From: Kate Giddings <kate.giddings@arun.gov.uk>
Sent: 26 February 2020 12:36
To: David Spring <David.Spring@arun.gov.uk>
Cc: Planning.Responses <Planning.Responses@arun.gov.uk>
Subject: BE/19/20/DOC - Site 6 Chichester Road, North Bersted

Having now reviewed the Construction Environmental Management Plan (undated, unreferenced) for the above site, it is understood that this document is the same as submitted under BE/84/19/PL. Please may the following points therefore be addressed:

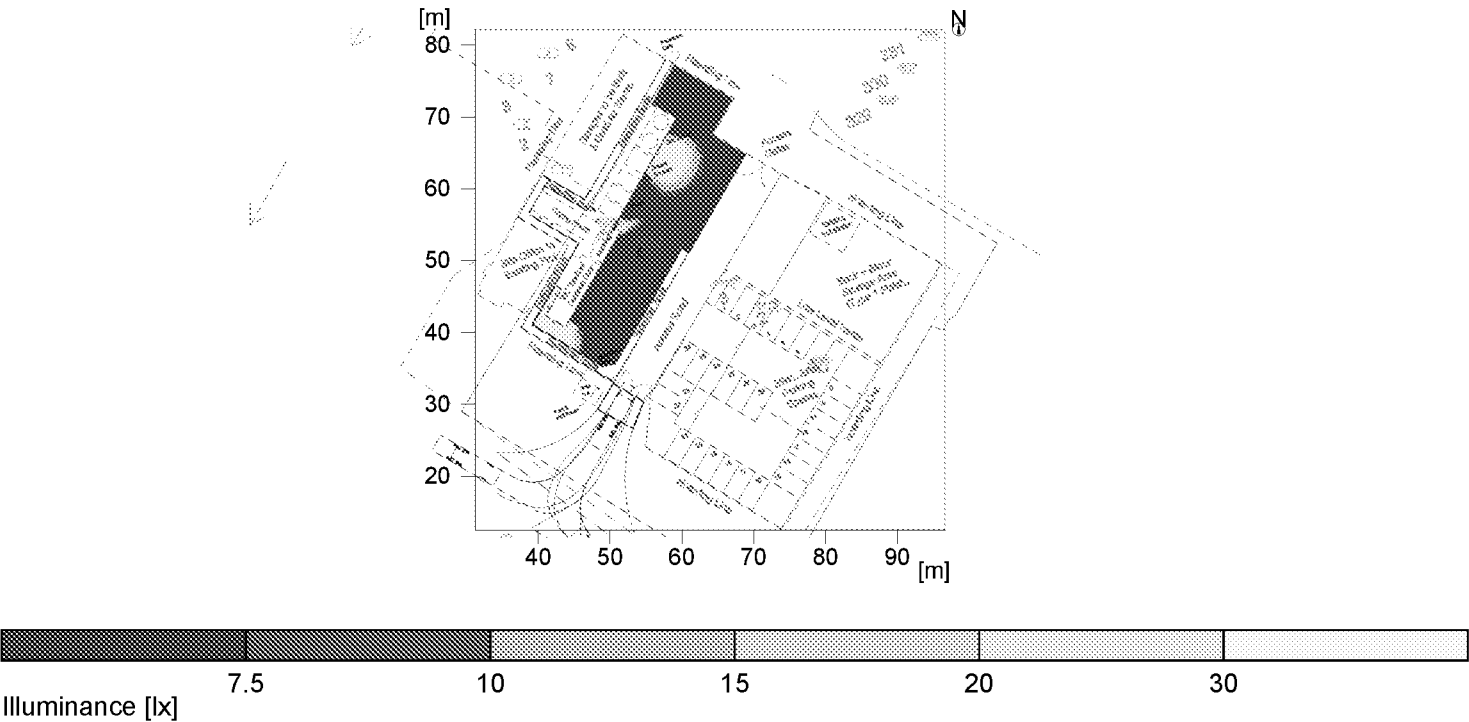
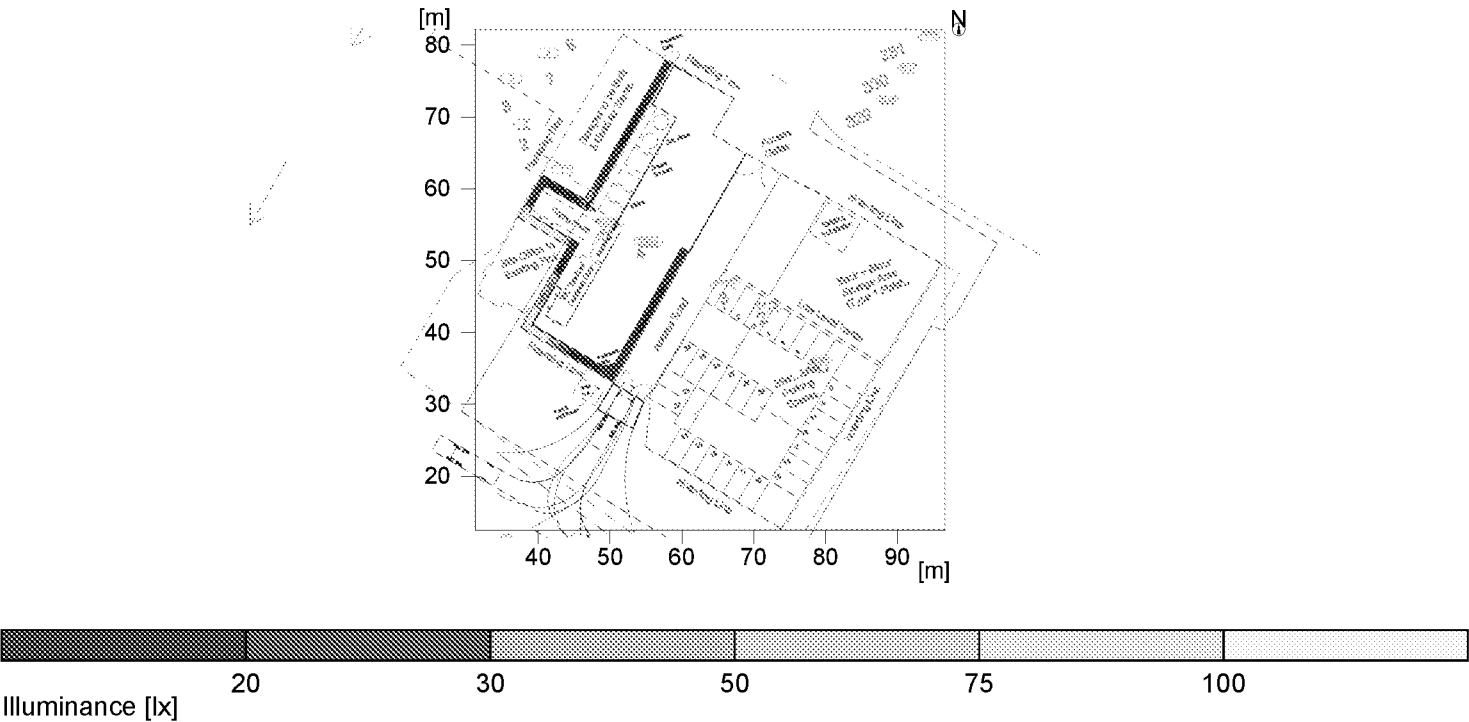
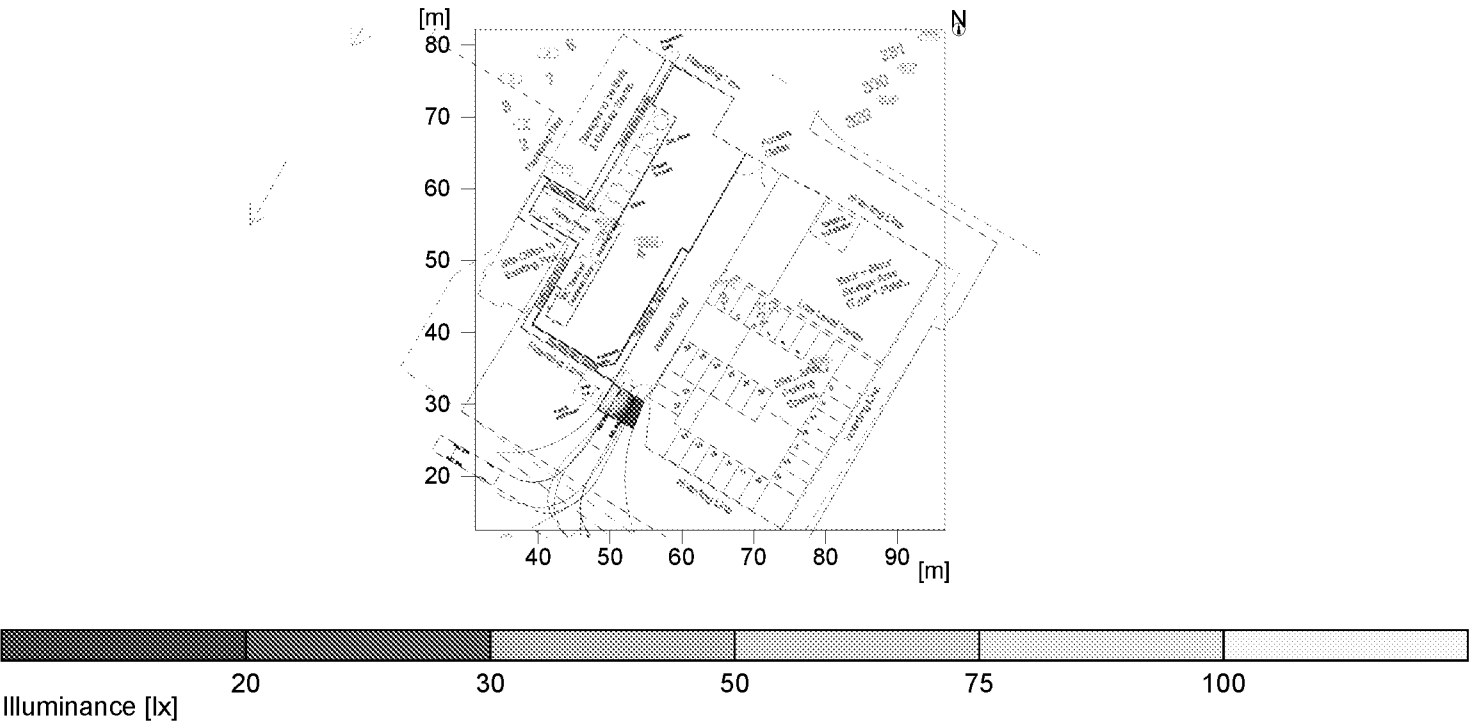
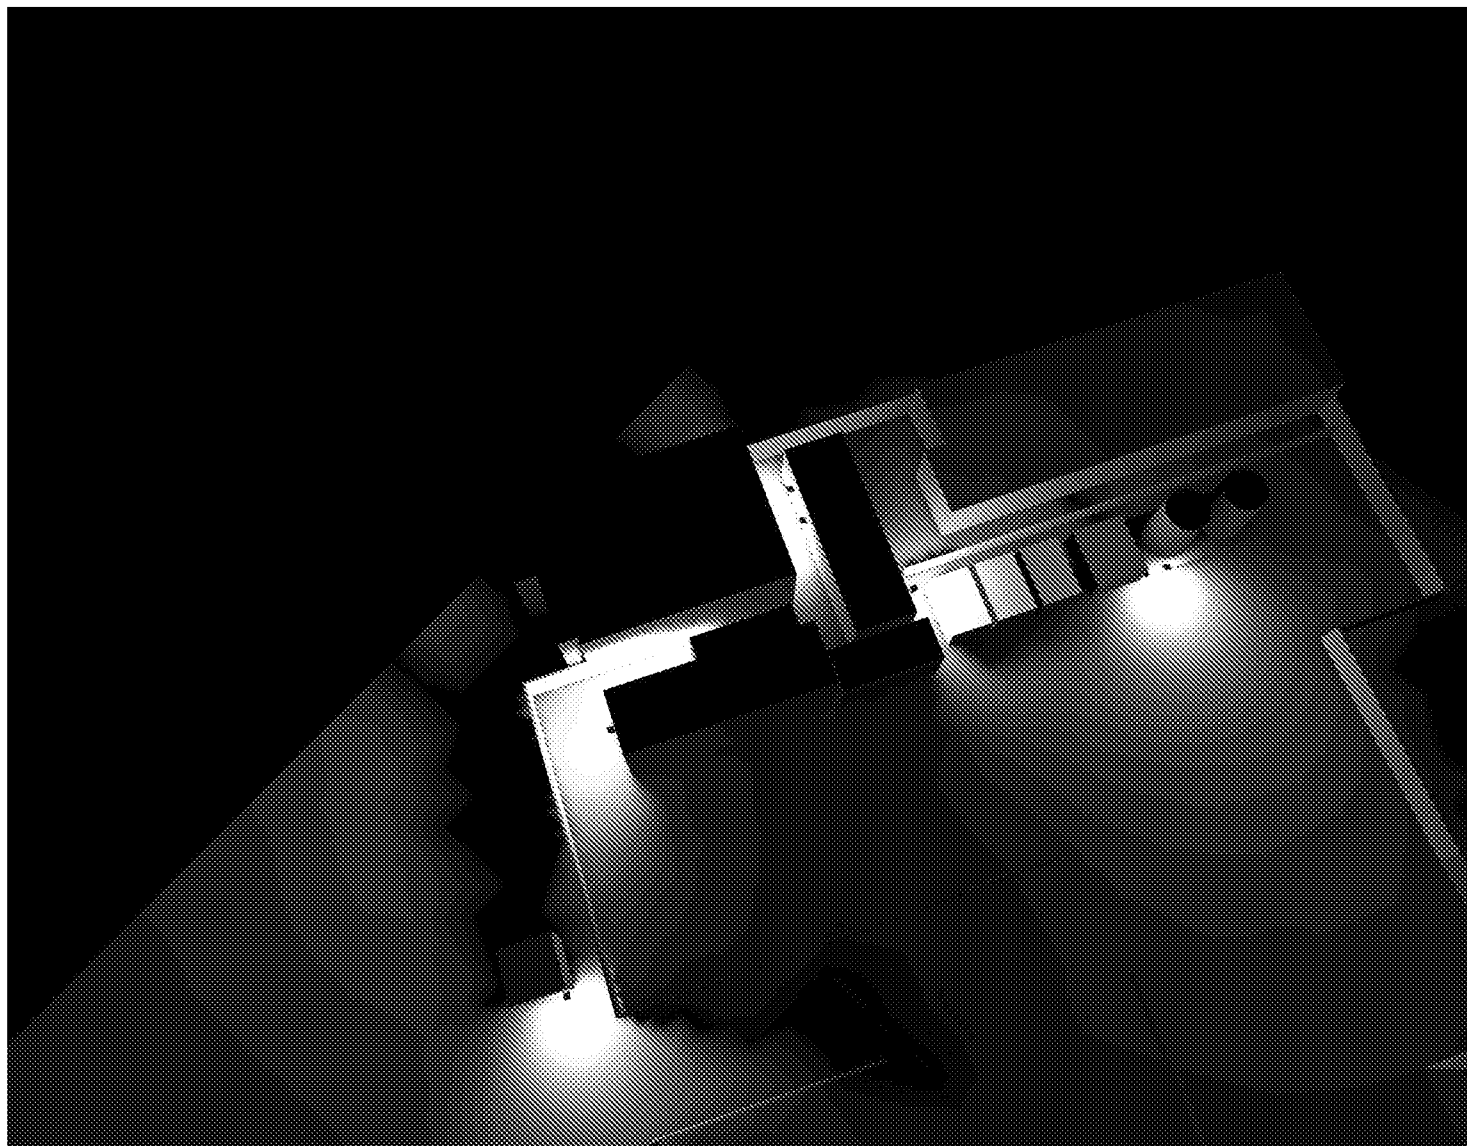
- Water Quality, Drainage and Hydrogeology section; this aspect may require consultation with the Environment Agency.
- Light Pollution; greater detail in this section should be provided (for example, location, type, intensity, etc.). It is appreciated that this may become apparent once the main contractor and development schedule have been confirmed.
- There are a number of typographical errors throughout the report which makes some sections less easily understood.
